Rezoning Petition Review

Rezoning Petition #: 08-136

Location of Property: Approximately 3.35 acres located on the west side of Johnston Road between North Community House Road and Torrington Way.

ILLUSTRATIVE SITE PLAN
DATE: 07.22.08
SCALE: 1" = 40'
JOB NO. X8032.00
SHEET: RZ-1

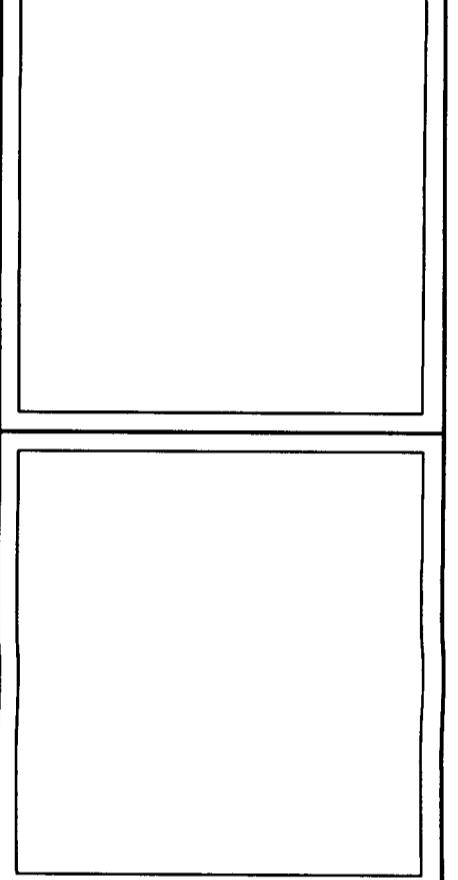
Concerning Storm Water: Add the Following Note:

The petitioner shall comply with the Charlotte City Council approved and adopted Post Construction Controls Ordinance.
